Please ask for: Nicola Moore
Email: nicola.moore@arun.gov.uk
Telephone: Ext 37944
Our Ref: LU/315/20/PL
Your Ref:
Date: 24th November 2020

Application for Planning Permission

Development: Subdivision of current A1 unit into two with replacement shop front. This application is in CIL Zone 4 (Zero rated) as other development.
Location: 47 Pier Road Littlehampton BN17 5LW

LOCATION & BLOCK PLANS

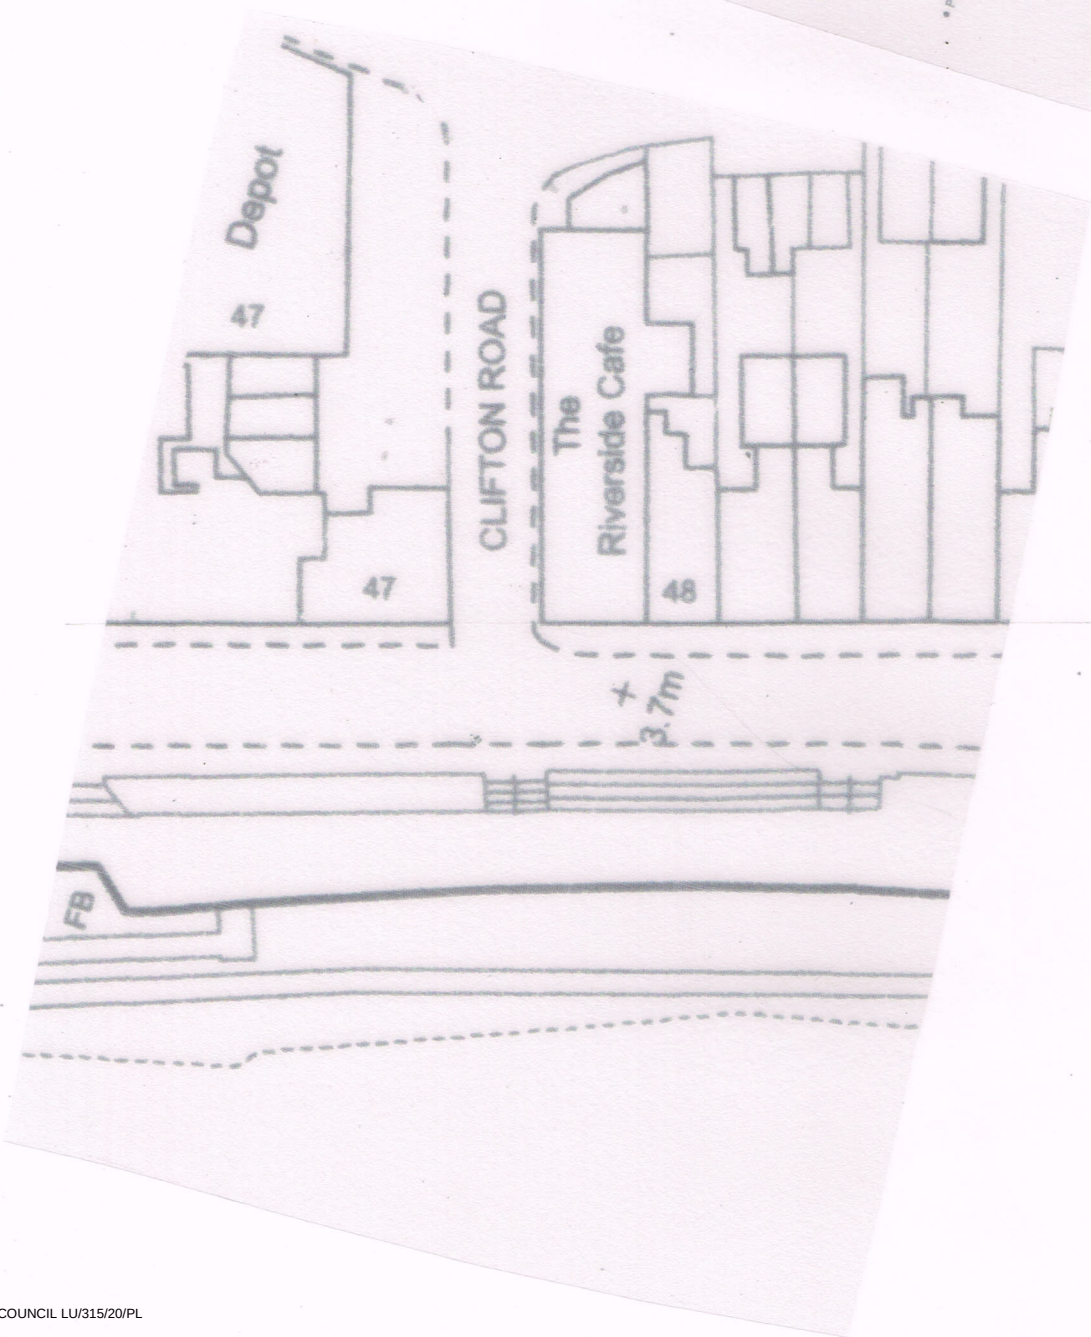
Block Plan

Please amend the Block Plan to clearly show the subdivision and the replacement window and re submit.
